PROJECT: Smith's #448
8301 Golf Course Road, NW
Albuquerque, NM 87120

RE: **Administrative Amendment, Accessibility Requirements comment**

Application reference: PR-2019-002643/ SI-2022-02251

VERTICAL
3/8" = 1'-0"

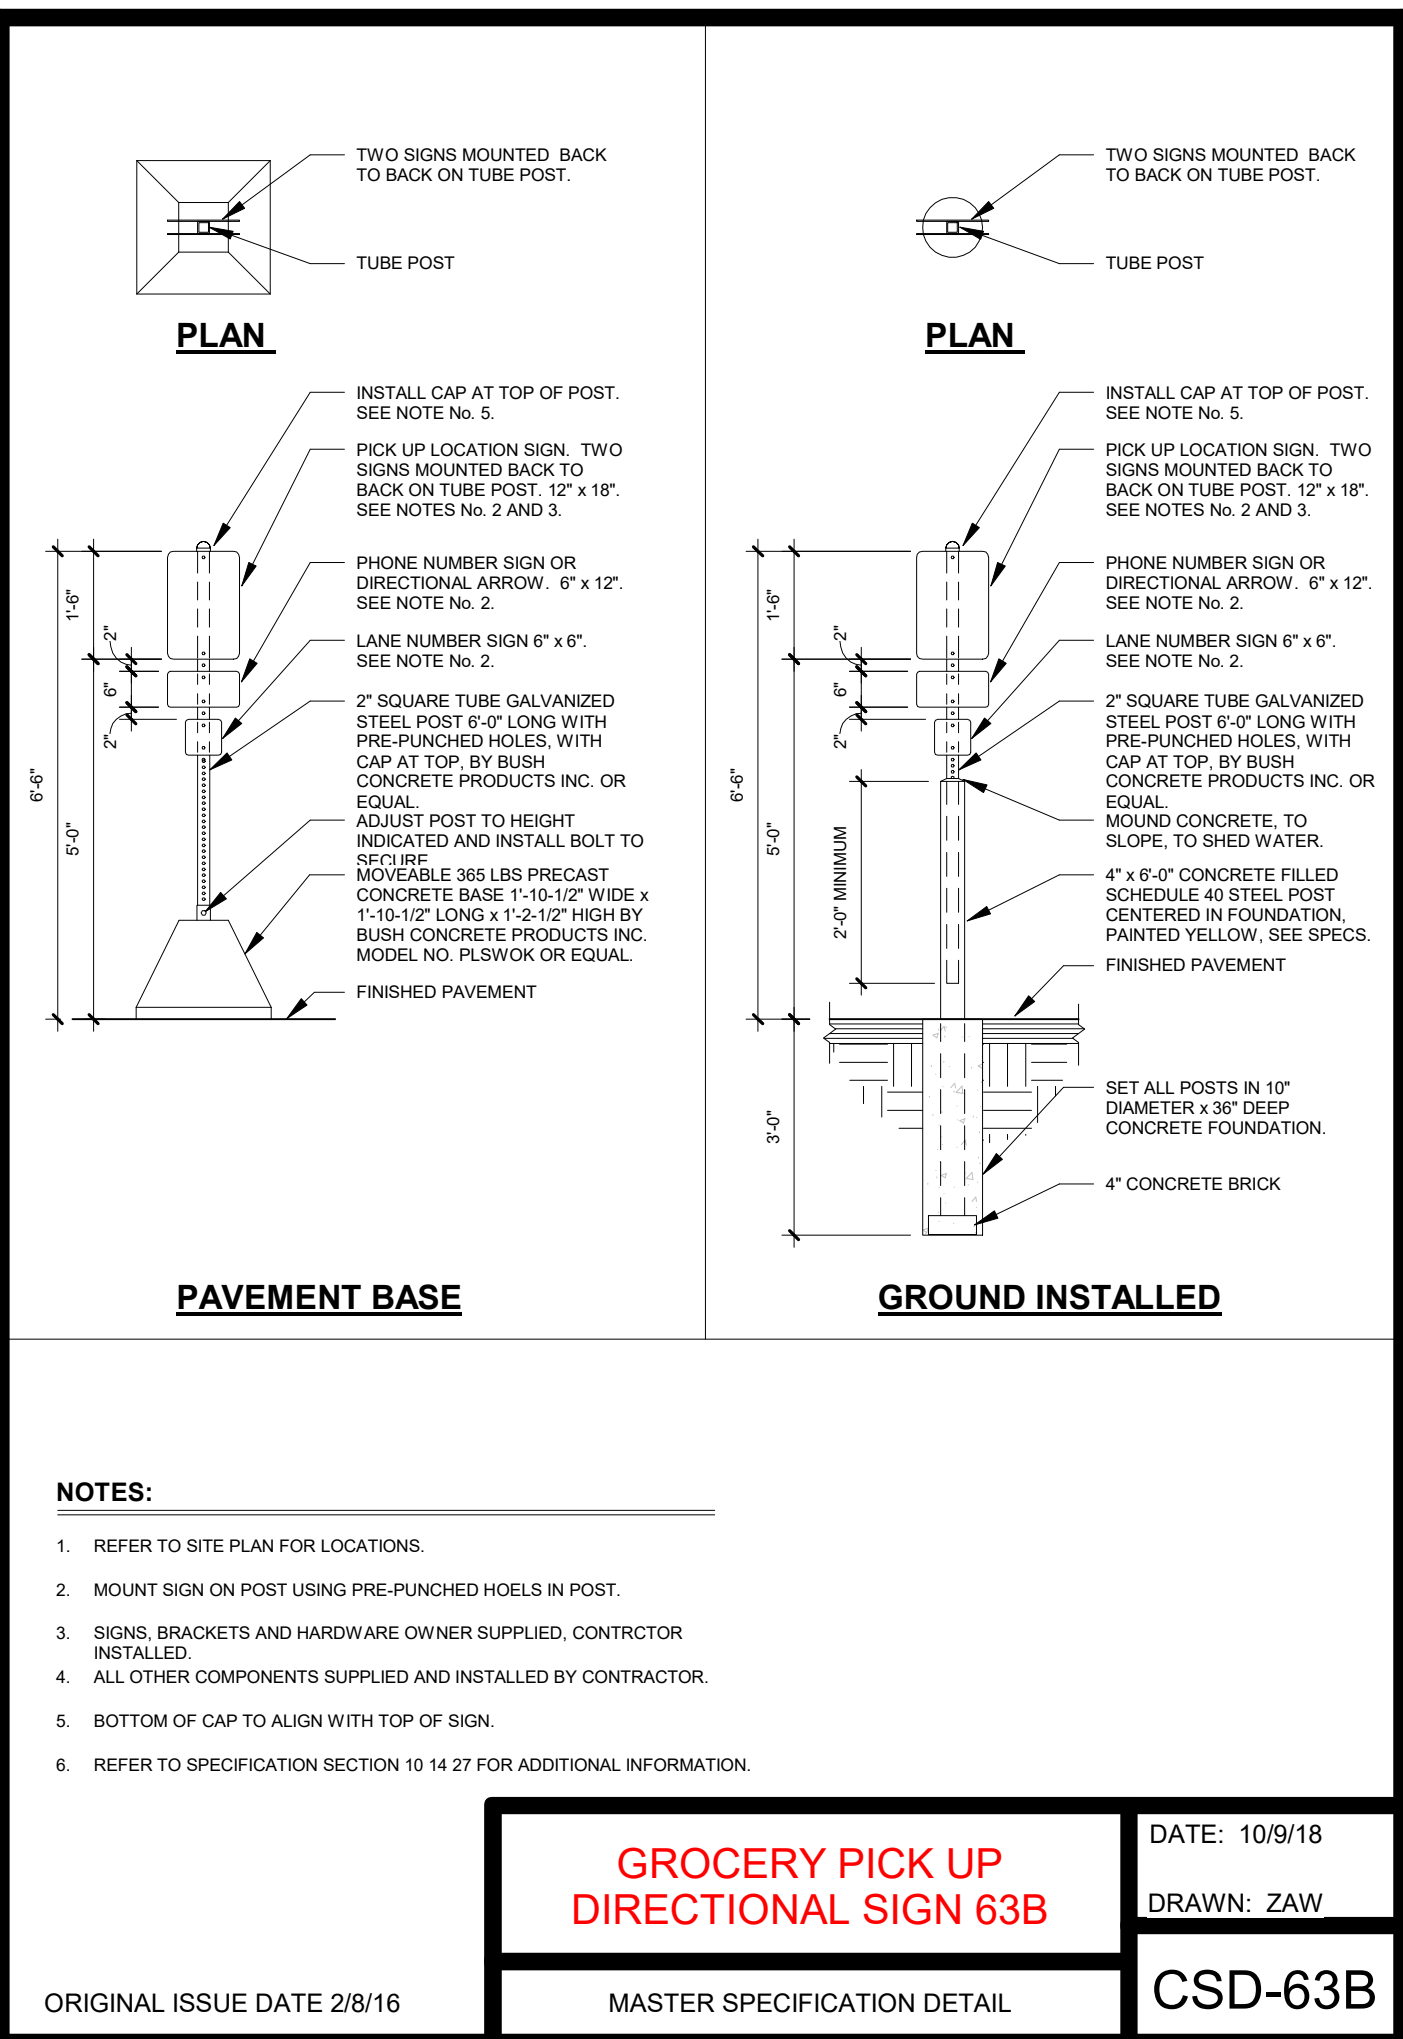
Good afternoon,
Please provide ADA access aisle (5 ft. wide) for the ADA parking space that adjacent to the proposed "PICK-UP" parking spaces. The ADA access aisles shall have the words "**NO PARKING**" in capital letters, each of which shall be at least one foot high and at least two inches wide, placed at the rear of the parking space so as to be close to where an adjacent vehicle's rear tire would be placed. (66-1-4.1.B NMSA 1978)

Mr. Marwa Al-najjar,
Please, see attached the memo with the Accessibility requirements indicated per your review and the associated revised sheets A0.1 and A0.2 with the required corrections, clouded and identified with a delta #1 and today's date.
Kind regards
